Submission to the Department of Planning, Housing and Infrastructure

SSD SSD-86270706 – 5 Blue Street, North Sydney (Zurich Building)

Figure 6.11: East and west elevations
Source: fjstudio 2026

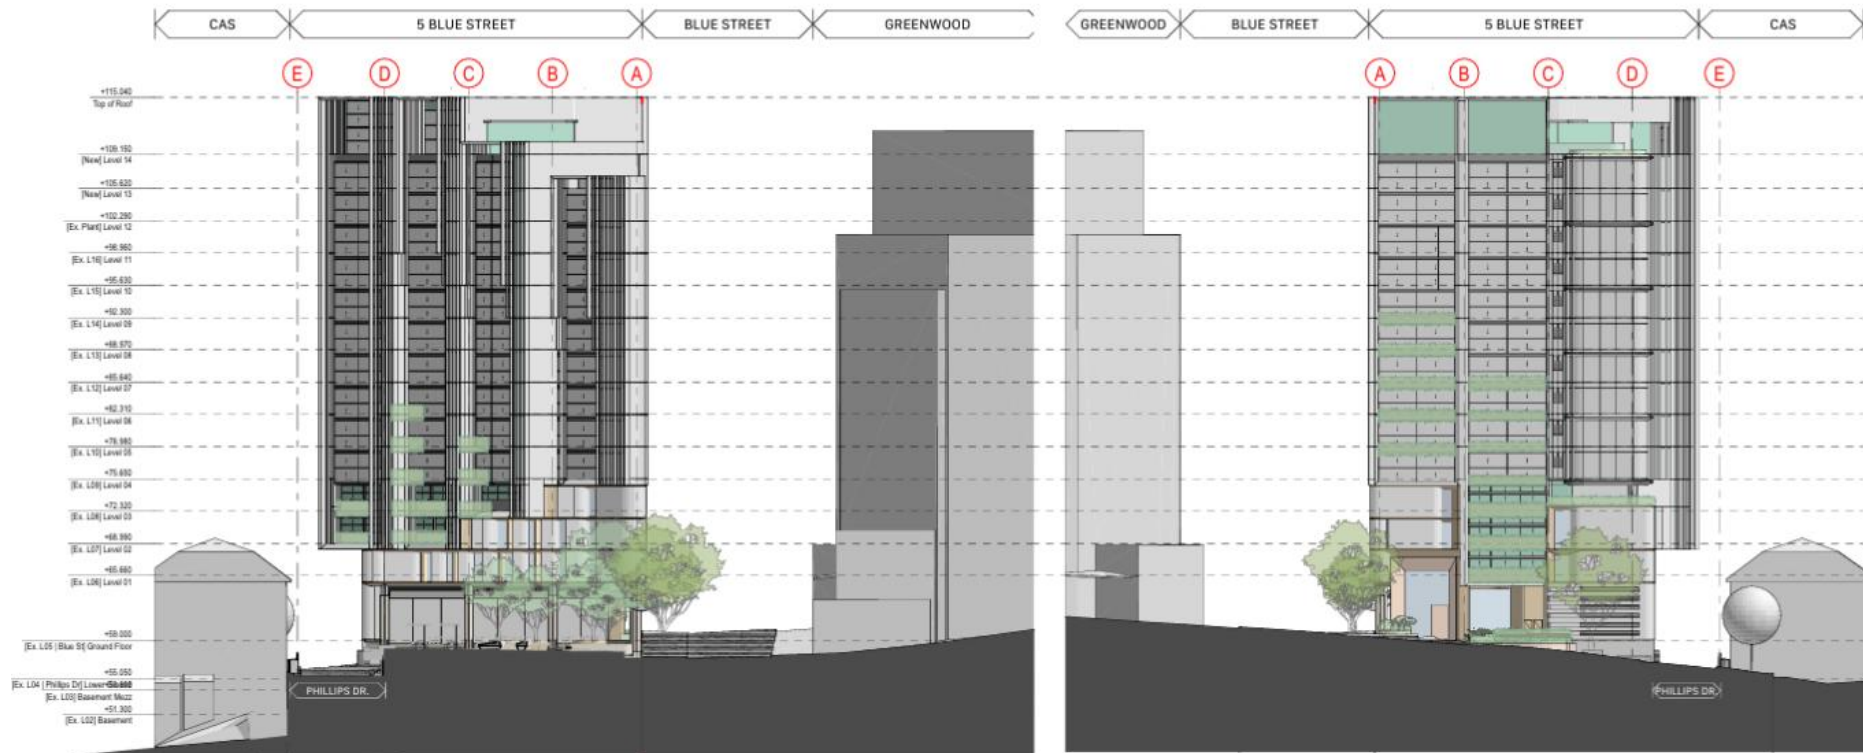
From the EIS, my understanding is that an amendment is in part required because the proposed eastern extension and cantilever framework projects beyond the existing building envelope and above Blue Street Plaza, according to the feedback at community consultation, this extension overhangs the Blue Street Plaza by an average of approximately two metres. The planning changes sought to accommodate this extension is unnecessary and disproportionate, a relatively small design change to ensure that the eastern extension does not overhang the Blue Street Plaza, therefore removing the need to amend the Blue Street Plaza height control and reducing the solar impact on residential properties to the south would be a more appropriate result.

I respectfully request that the Department require the applicant to redesign the eastern extension so that it remains within the existing RL65 envelope over the Blues Street Plaza and preserves the existing solar access for residential land outside the North Sydney Centre between 10:00 am and 2:00 pm.

- redesign of the eastward extension of the upper seven storeys and the cantilevered structure over Blue Street Plaza in order to retain the RL65 height limit for Blue Street Plaza and reduce the impact of overshadowing to residential premises to the South;
- a comprehensive cumulative impact assessment that includes the Lavender Street/Middlemiss Street proposal and updated assessment alongside the Fujitsu and St Francis Xavier proposals which is made available for public exhibition.
- The three sites of Zurich Building, Fujitsu Building and St Francis Xavier Church Development should be assessed and viewed together under a precinct plan as proposed by North Sydney Council;
- standard construction hours;
- additional acoustic assessment for Wilona Avenue and other downslope receivers with appropriate mitigations.

Figure 6.12: Southern elevation
Source: fjstudio 2026

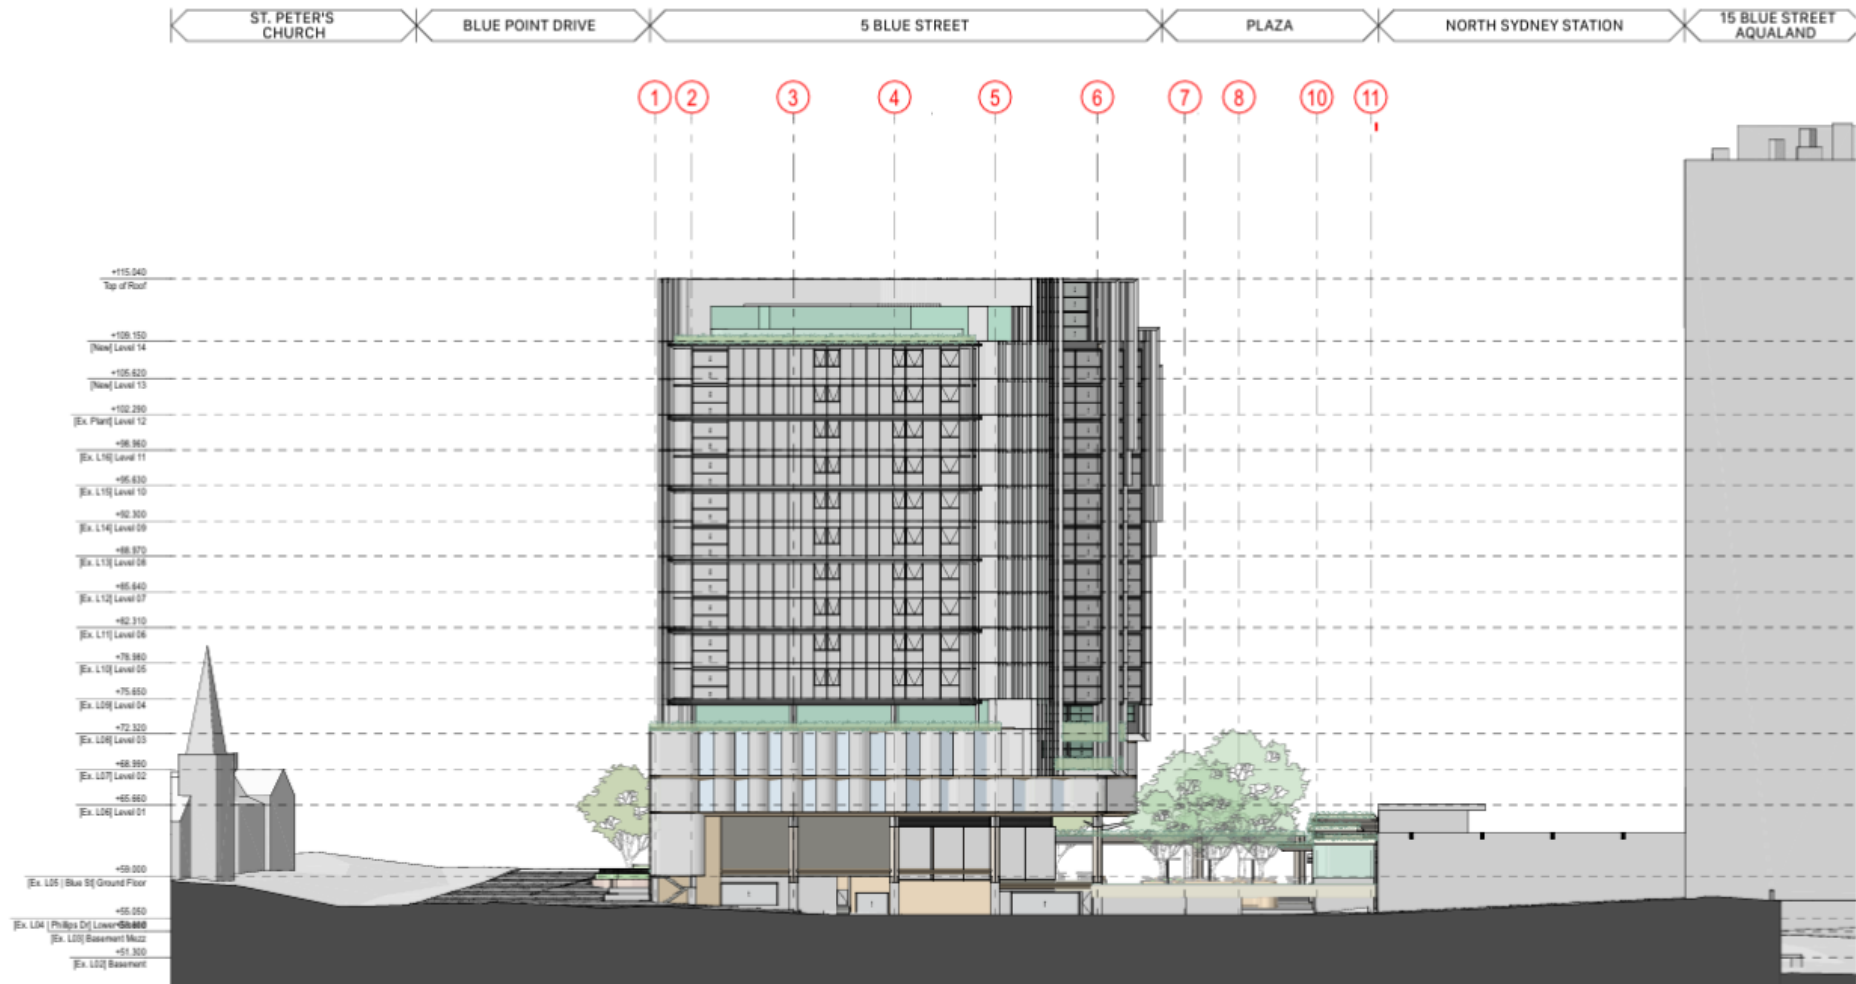
The increase in the width of the building, resulting from the eastward extension of the upper seven storeys and the cantilevered structure over Blue Street Plaza, will reduce the solar access to my property by approximately one hour on the winter solstice.

Although the shadow diagrams in the Appendix clearly show that Wilona Avenue properties are affected by additional overshadowing from the proposal, the EIS does not assess these impacts because the properties continue to receive more than two hours of direct sunlight on 21 June. The two hour benchmark is a minimum planning guideline, not a threshold below which impacts become relevant and above which they can be ignored. A proposal may comply with that benchmark while still causing a significant loss of residential amenity.
